DRAINAGE AND TRANSPORTATION SHEET
(REV. 1/28/2003rd)

PROJECT TITLE: Bruckner's Truck Sales ZONE MAP/DRG. FILE # J-09-Z
DRB #: 1008585 EPC #: _____ WORK ORDER #: _____

September 20, 2012

**RE: BRUCKNER'S TRUCK SALES,
DRAINAGE REPORT AND GRADING PLAN COMMENT RESPONSE
ENGINEER'S STAMP DATED: 7/19/12 (J09/DO21)**

BRUCKNERS TRUCK SALES GRADING AND DRAINAGE CONTOURS	DRAWN BY BJF DATE 12/10/12 2011073_GRB
	TIERRA WEST, LLC 5571 MIDWAY PARK PLACE NE ALBUQUERQUE, NM 87109 (505) 858-3100 www.tierrawestllc.com	SHEET # C2.1
	CITY PROJECT No. 655782	SHEET OF 03.1 09

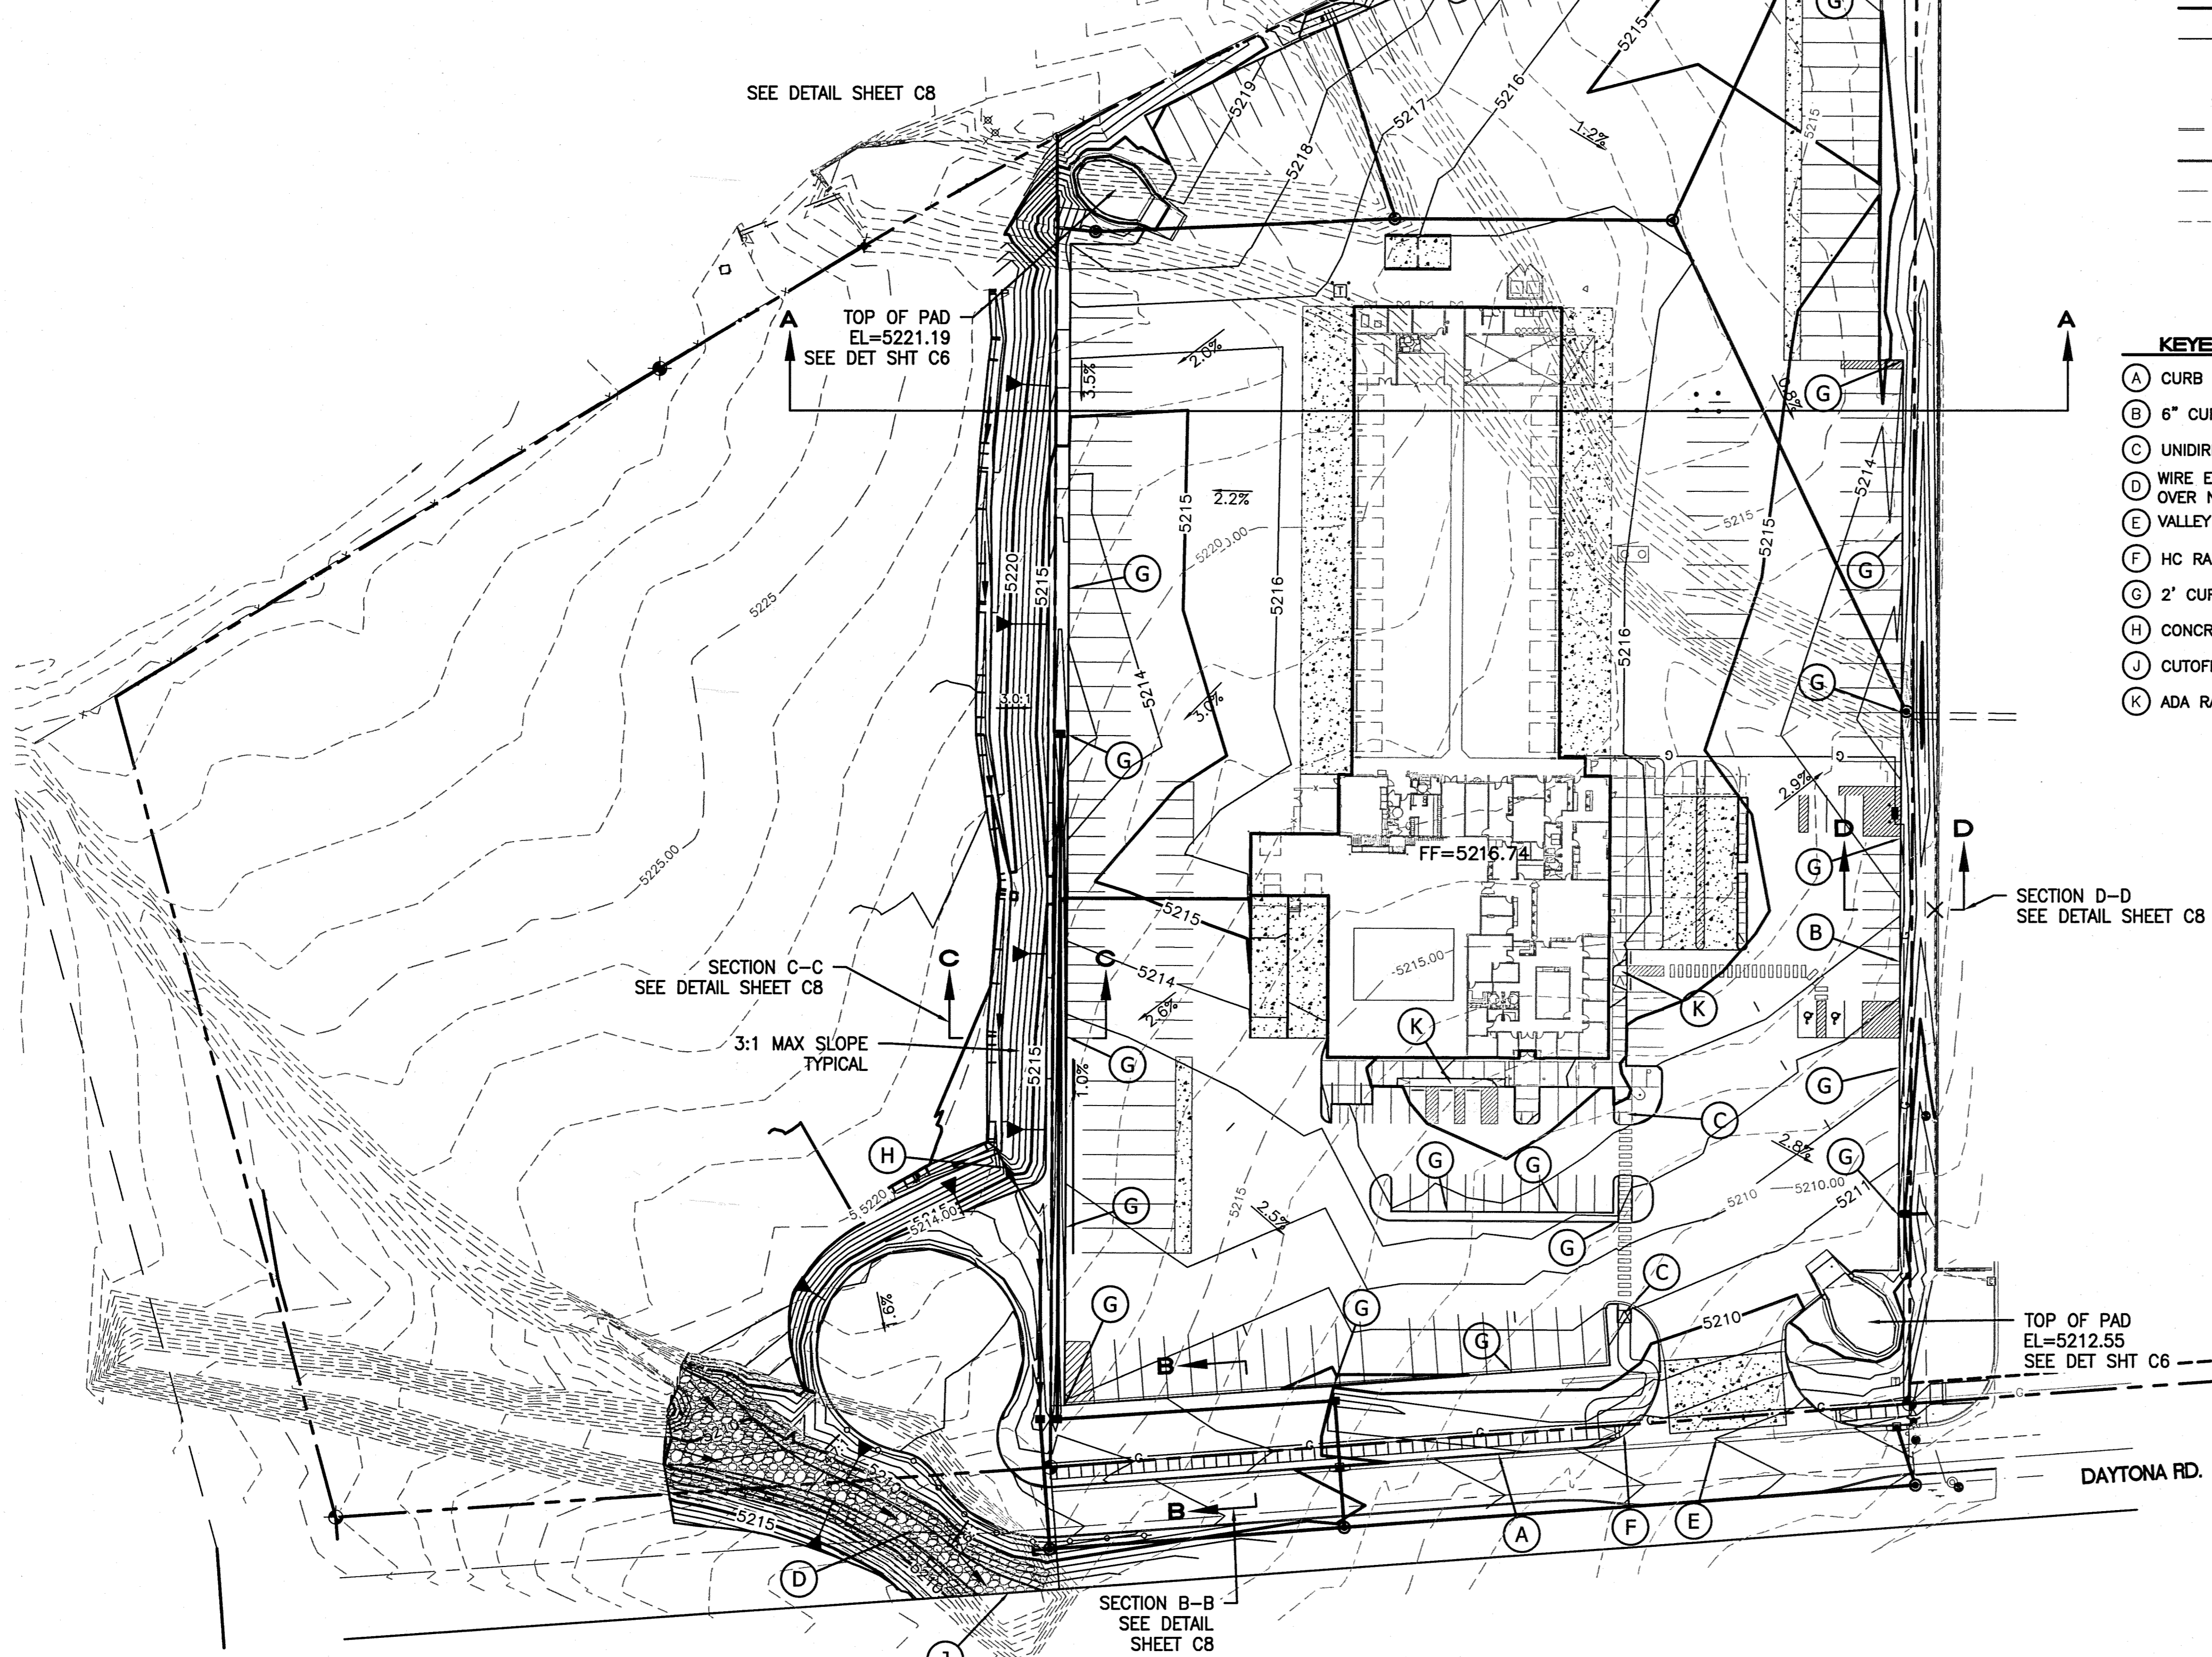
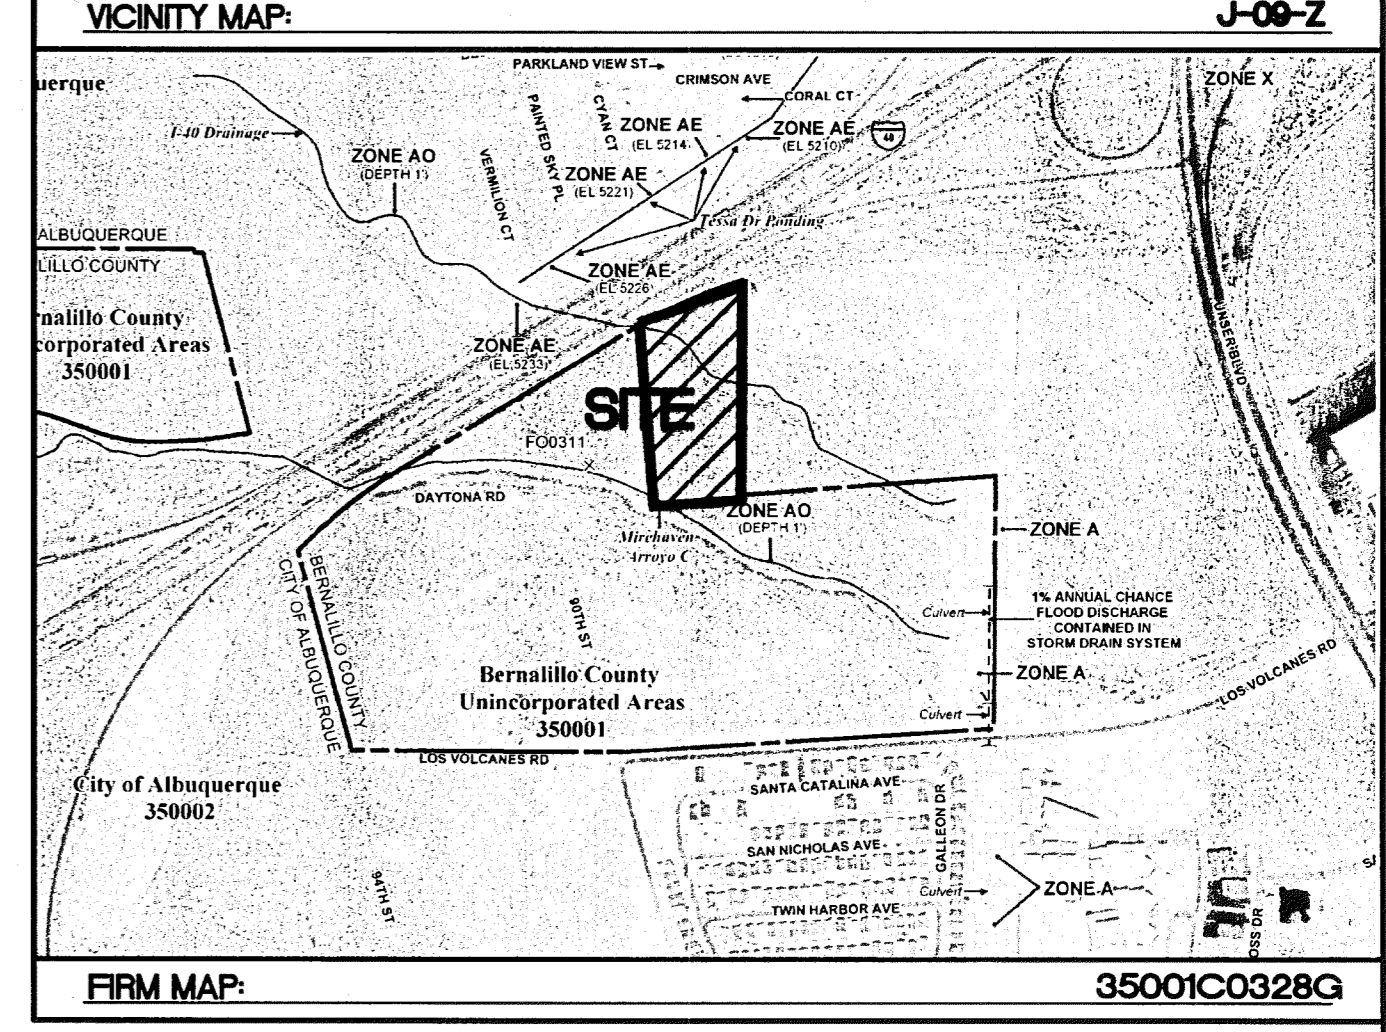
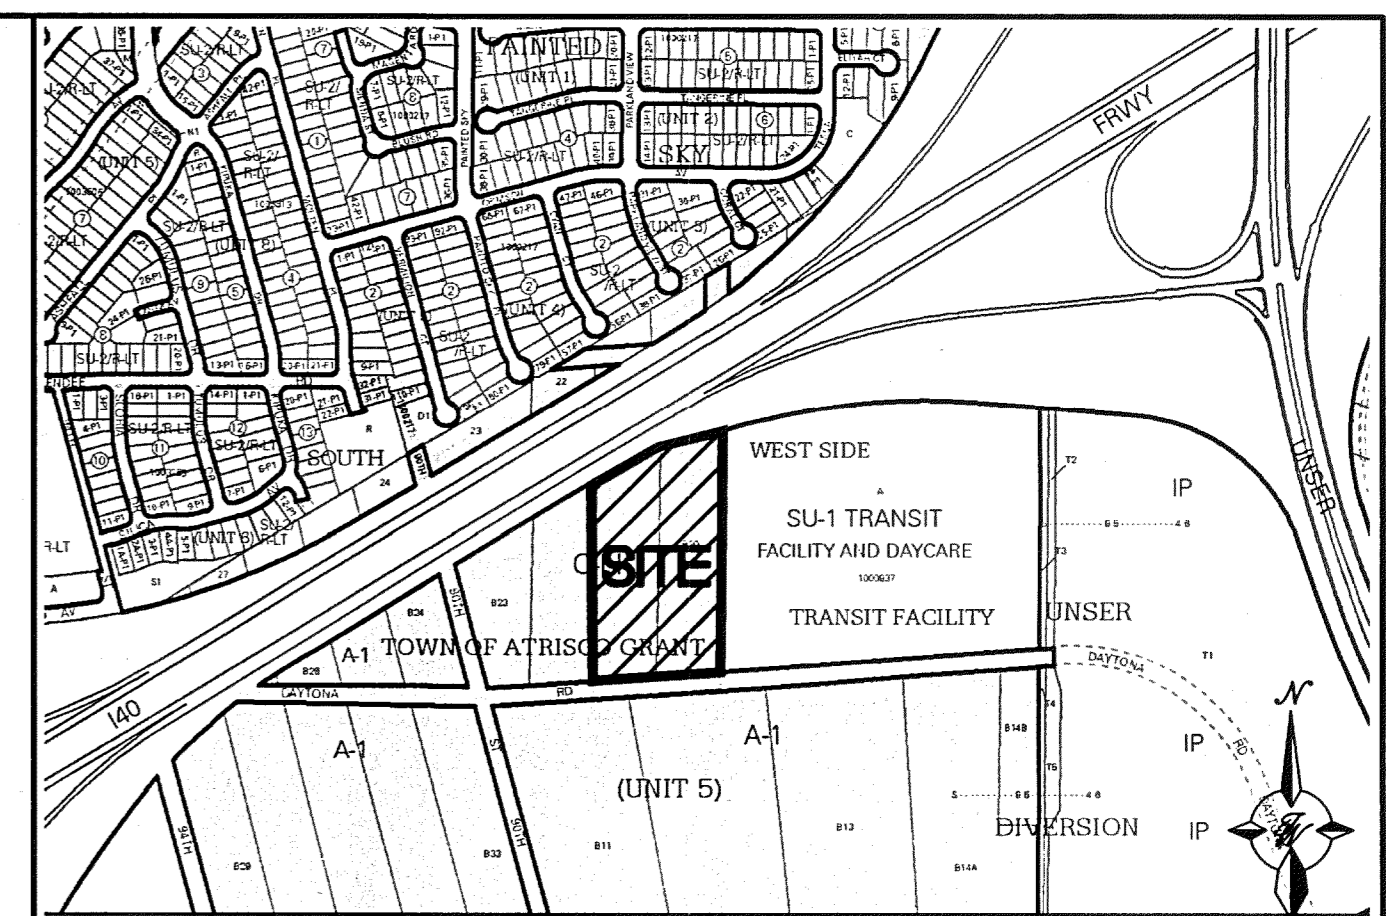
3. Please provide erosion and scour analysis passed the enclosed riprap for the channel. Would scour wall be required at the end of the riprap?
Attached, please find the channel analysis results for the area in question. The analysis shows that the velocities are within the acceptable range to prevent dangerous erosion and we have called out and detailed a cutoff wall for the end of the riprap and channel improvements.

< 5 fps, therefore okay

- (A) CURB & GUTTER PER COA STD DWG #2415B
- (B) 6" CURB & GUTTER (SEE DETAIL SHEET C6)
- (C) UNIDIRECTIONAL RAMP (SEE DETAIL SHEET C7)
- (D) WIRE ENCLOSED RIPRAP, CLASS "A" 1.0 FT. THICK OVER NON-WOVEN GEOTEXTILE CLASS "1"
- (E) VALLEY GUTTER
- (F) HC RAMP (SEE DETAIL SHEET C7)
- (G) 2' CURB CUT (SEE DETAIL SHEET C7)
- (H) CONCRETE V-DITCH (SEE DETAIL SHT C9)
- (J) CUTOFF WALL (SEE DETAIL SHT C9)
- (K) ADA RAMP "C" (SEE DETAIL SHT C7)
